Matthew C Birch
RE: M1/11/ Resubmission

DRAWING	SCALE
PROPOSED FIRST FLOOR	1/50
DATE:	DECEMBER 2010
DRAWN:	T. Murray
DRAWING:	10/63/3
REVISION:

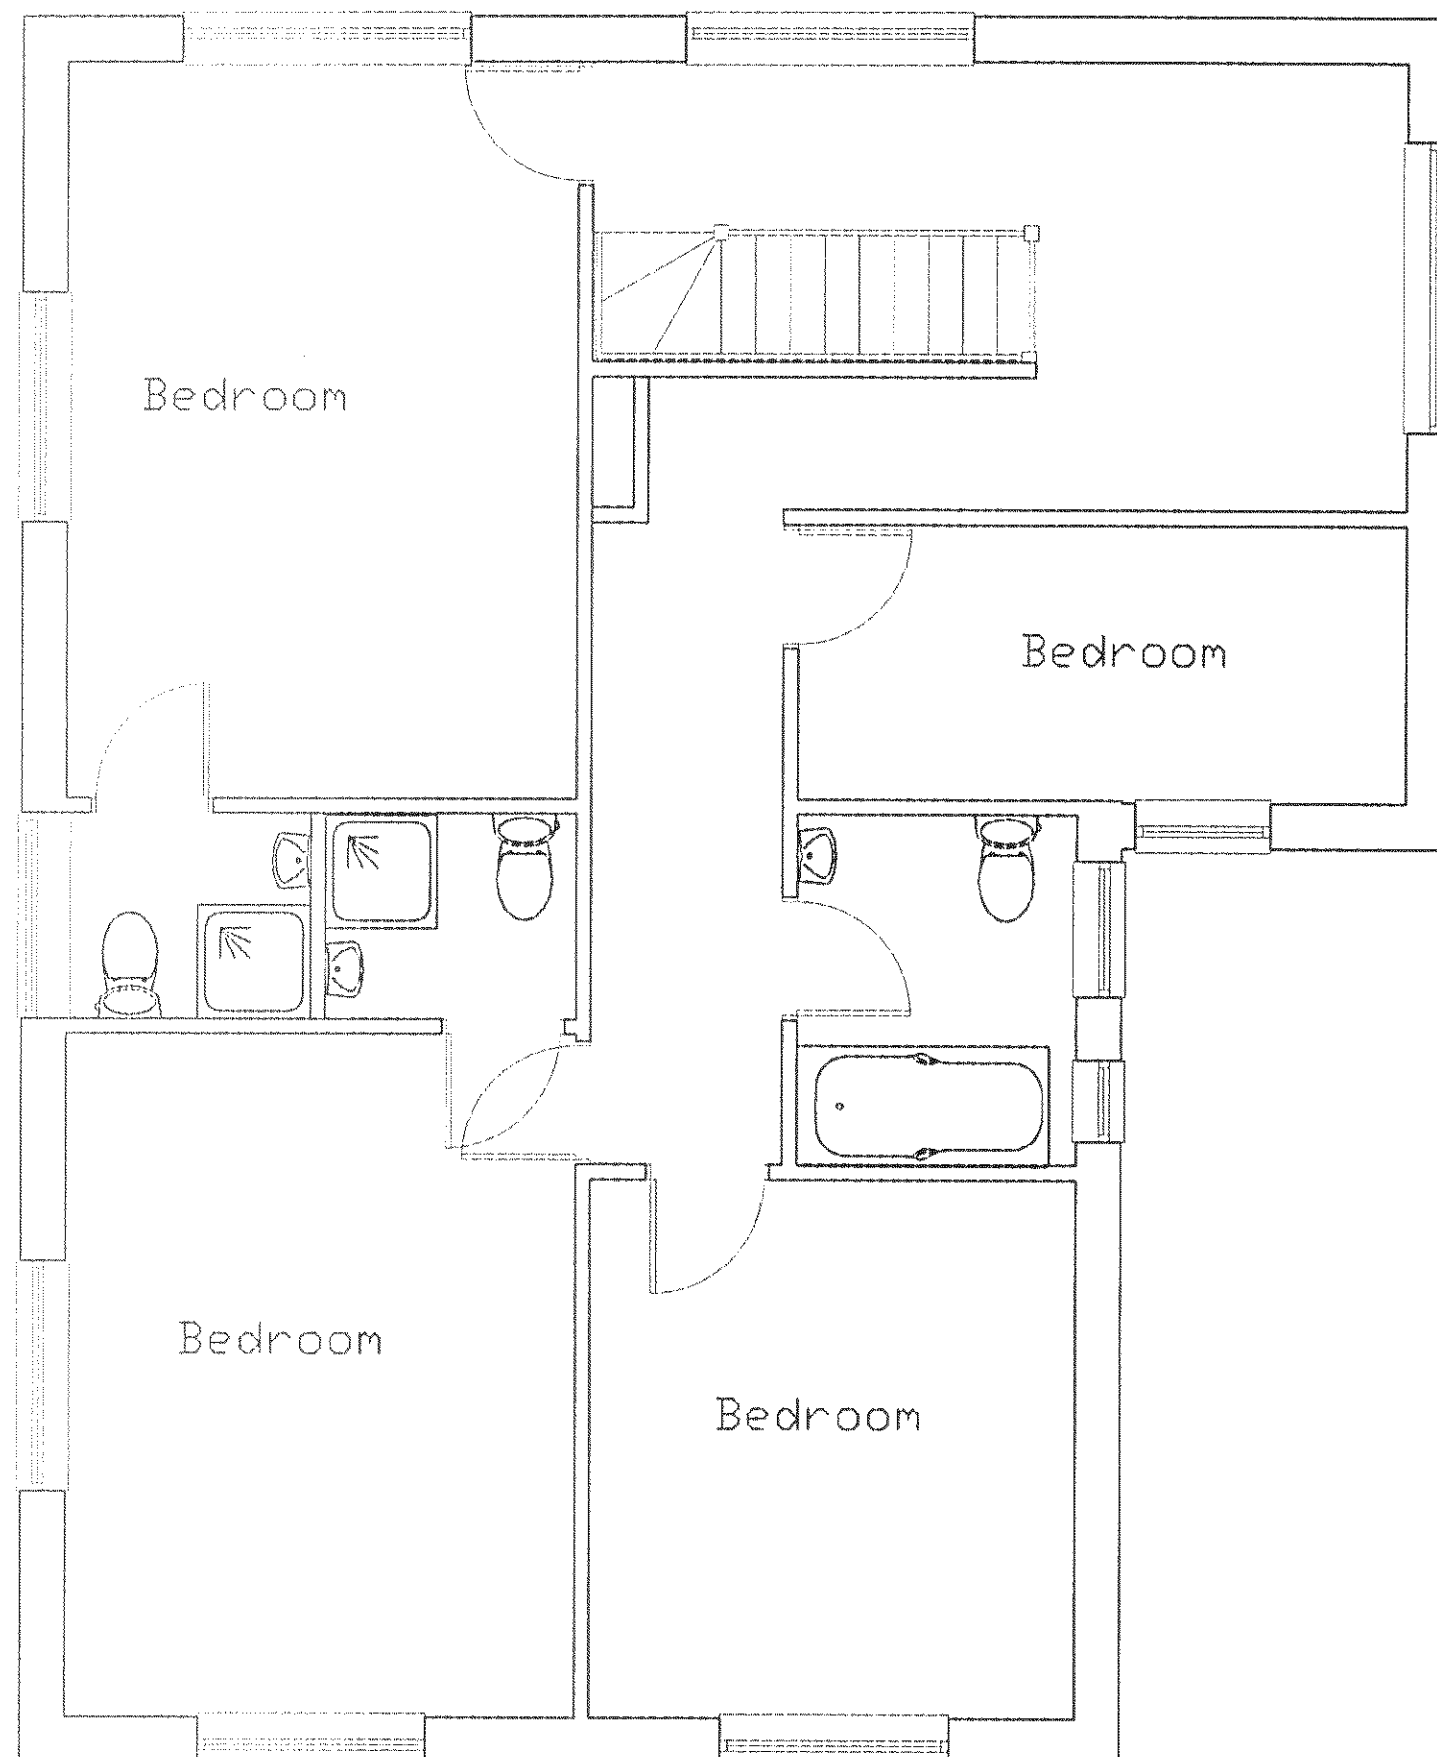
I have discussed the plans with my team leader Mr Parsons and we are both of the opinion that the dormers are too large and appear out of character with the existing dwelling. It would be more appropriate to have small dormers and scale down the accommodation at first floor level.

> The floor plans are ok but I am unable to view the elevations which
> shows me error reading file.
